From: Raymond Cole <Raymond.Cole@arun.gov.uk>
Sent: 23 February 2021 10:41
To: Planning.Responses <Planning.Responses@arun.gov.uk>
Subject: FW: BN/142/20/OUT: Land south of Barnham Station

Subject: BN/142/20/OUT: Land south of Barnham Station

As submitted, the proposed vehicular access is applied for in detail from Marshall Close to a location some way in to the site (Plan Ref: ITB14160-GA-005 Rev C). This is reflected graphically on the submitted parameter plan (Plan Ref:1311.04).

FIGURE 48. Plan showing the main access to the site from Marshall Close (i-transport)

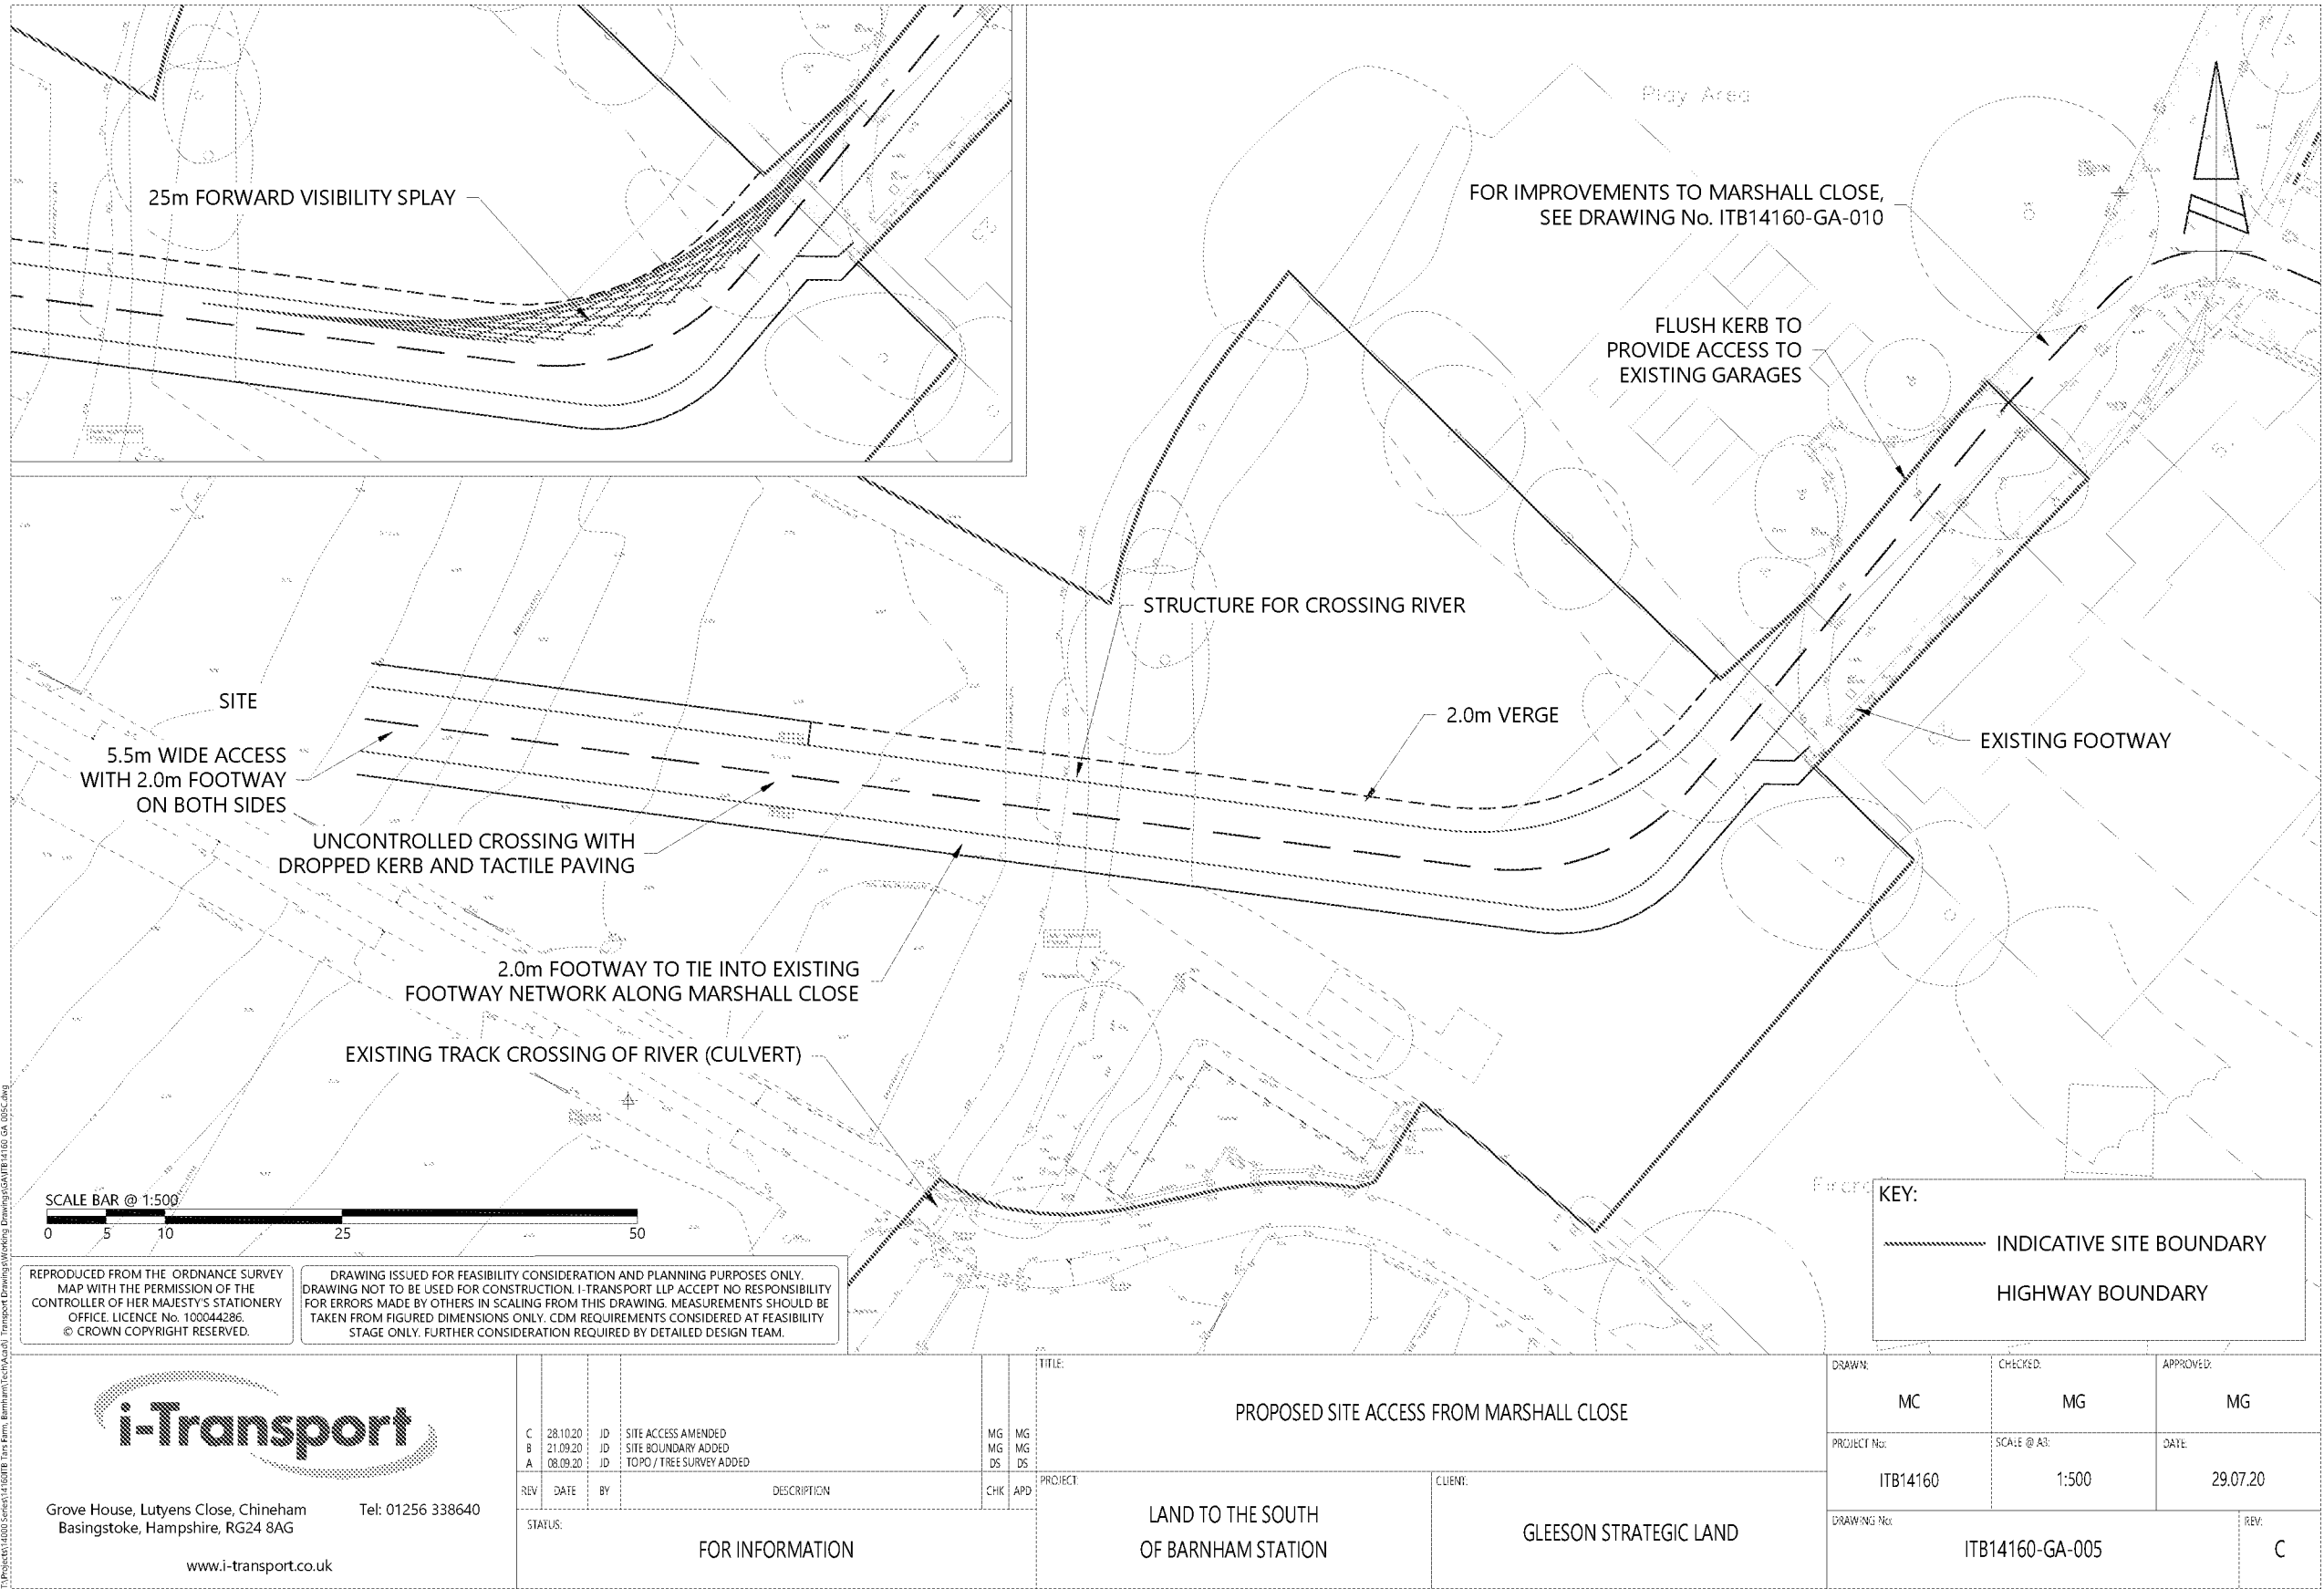
We request that this level of detail is amended such that the access details for consideration at outline stage extend only as far as is necessary to access the site (Plan Ref: ITB14160-GA-005 Rev D). The details of the access road within the site thereafter would be something for consideration, and consultation, at reserved matters stage (assuming that outline planning permission was granted). We do, however, propose that the original access plan is helpful at the outline stage for illustrative purposes.

Original Plan	Amended Plan
ITB14160-GA-005 Rev C	ITB14160-GA-005 Rev D (including indicative internal alignment) ITB14160-GA-017 (new drawing showing just connection between Marshall Close and Site)
ITB14160-GA-010 Rev A	ITB14160-GA-010 Rev B (Marshall Close Improvements)
1311.04	1311.04A
